**WEST SUSSEX COUNTY COUNCIL
INFRASTRUCTURE CONSULTATION**

SUBJECT: BE/136/10 - OUT application with some matters reserved for the erection of a terrace of 4 No. 2 bedroom houses. (Resubmission following BE/105/10)

Land Adjacent to, 346, Chichester Road, Bognor Regis, West Sussex

SITE PLAN

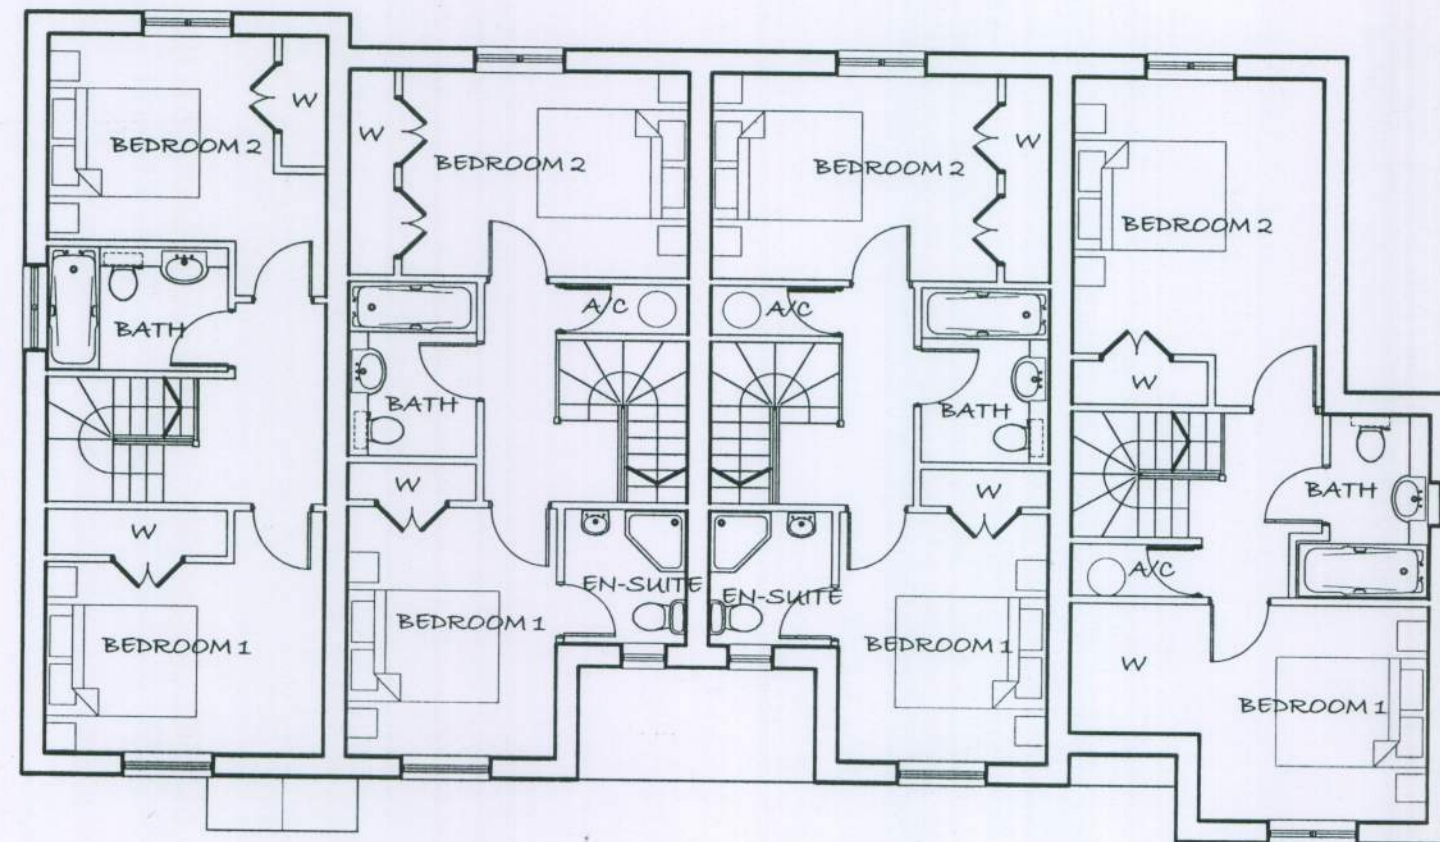
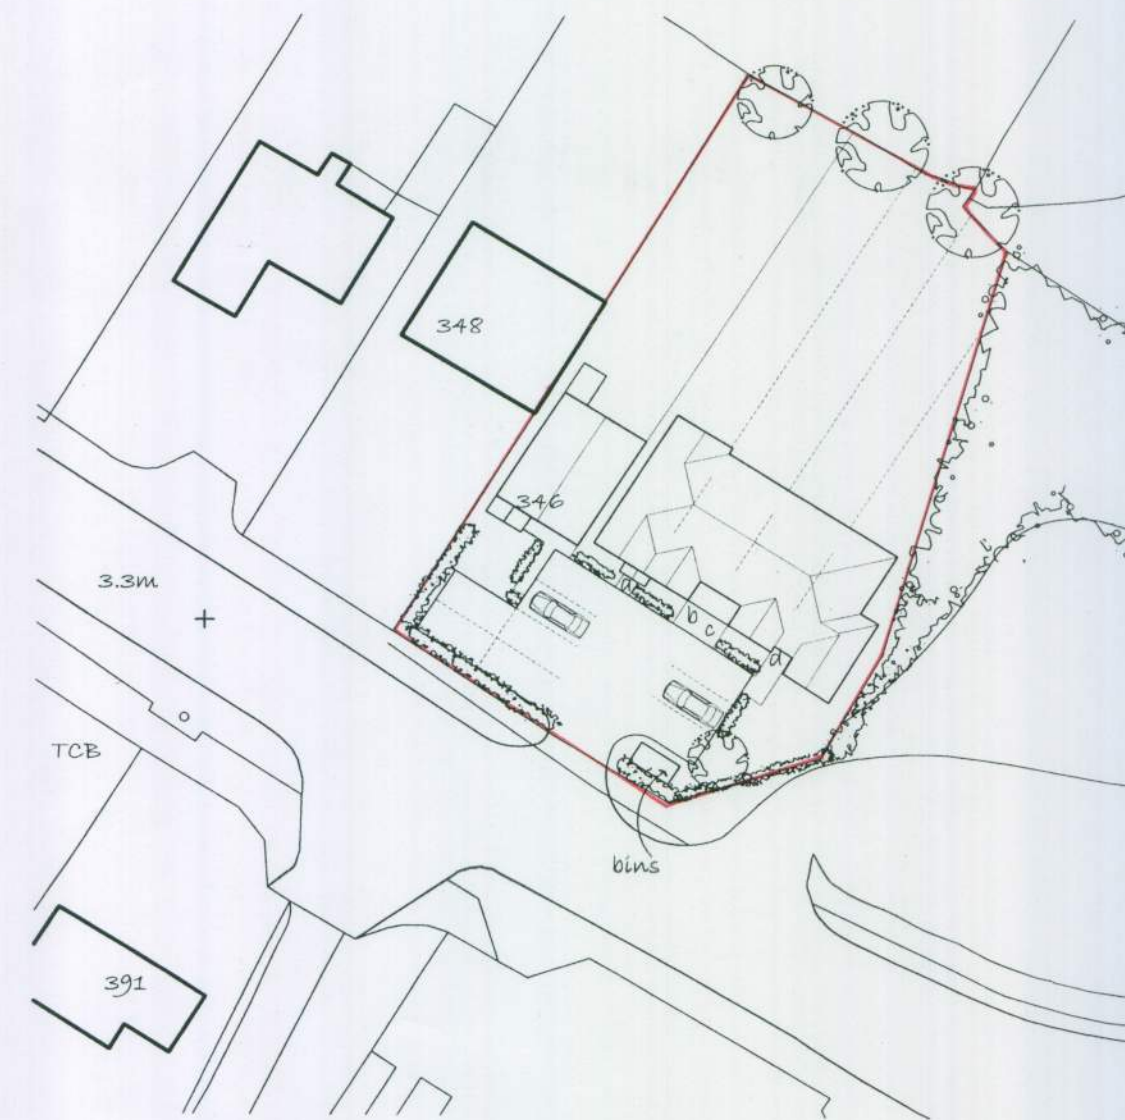
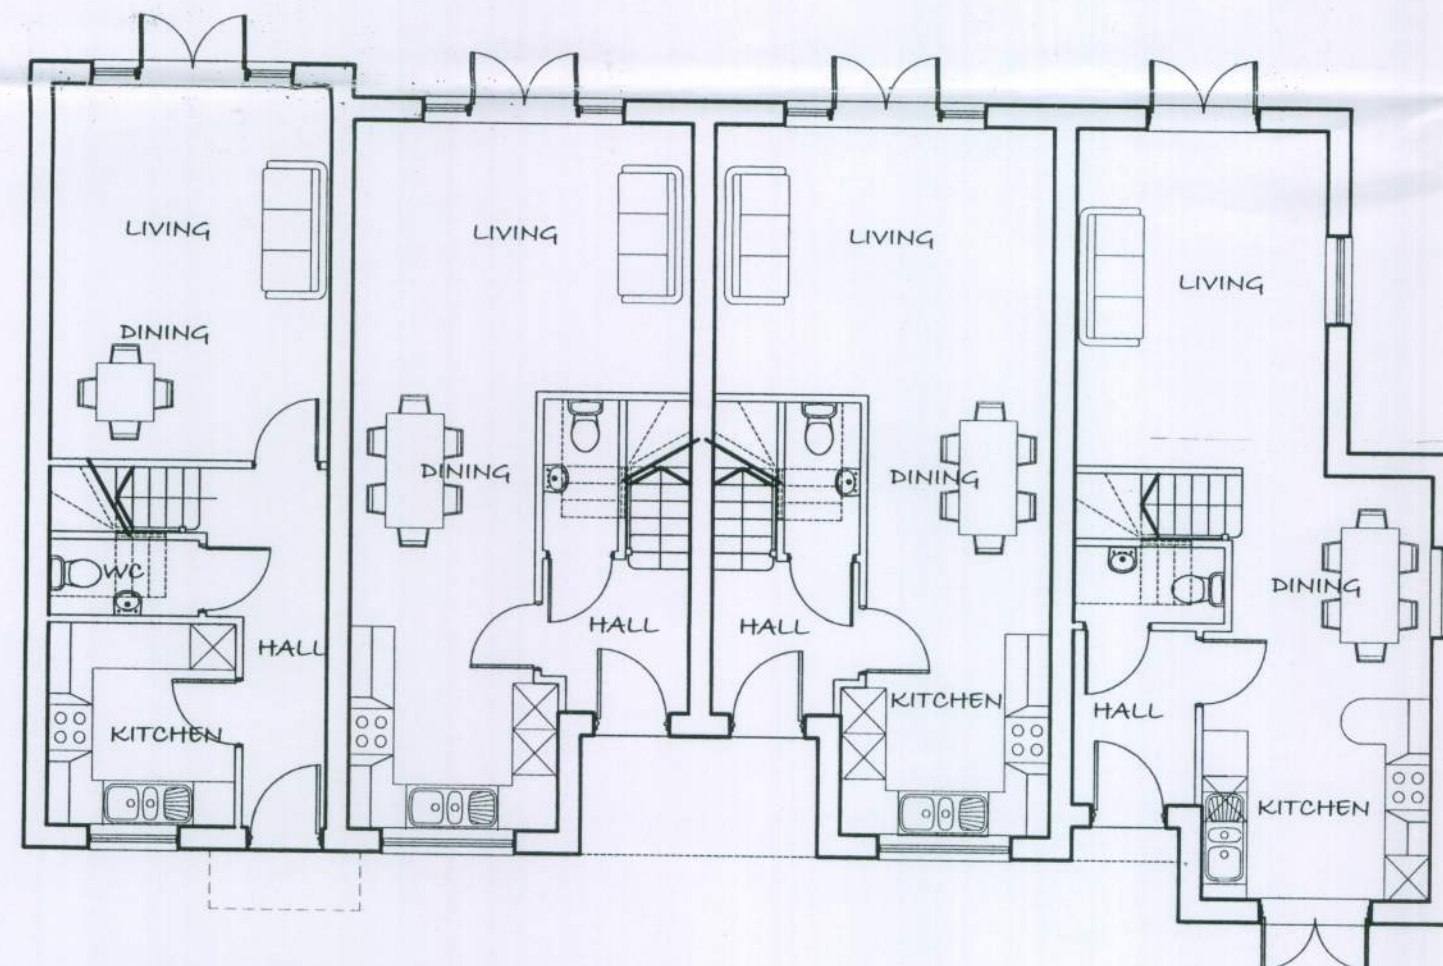
It is unclear as to how the parking scheme would function with the inclusion of two tandem car parking spaces. The applicant should clarify whether any of the spaces would be allocated to specific dwellings or whether they would remain unallocated. The dimensions of the car parking spaces and turning area should also be provided.

As stated in previous pre-application discussions, due to the close proximity of the existing access to the two heavily trafficked mini-roundabouts, the potential increase in right turning movements into the site increases the possibility of rear end shunts. Advice has been provided in the past indicating support for two additional dwellings, which would equate to three served from the single access. However, this was subject to the applicant designing a scheme that addresses the road safety issues. This has not been achieved as there is no mention of any highway safety improvements in the supporting information. Furthermore, the current application is for a more intensive scheme with a total of five dwellings served from the single access, which exacerbates the highway safety concerns associated with this proposal.
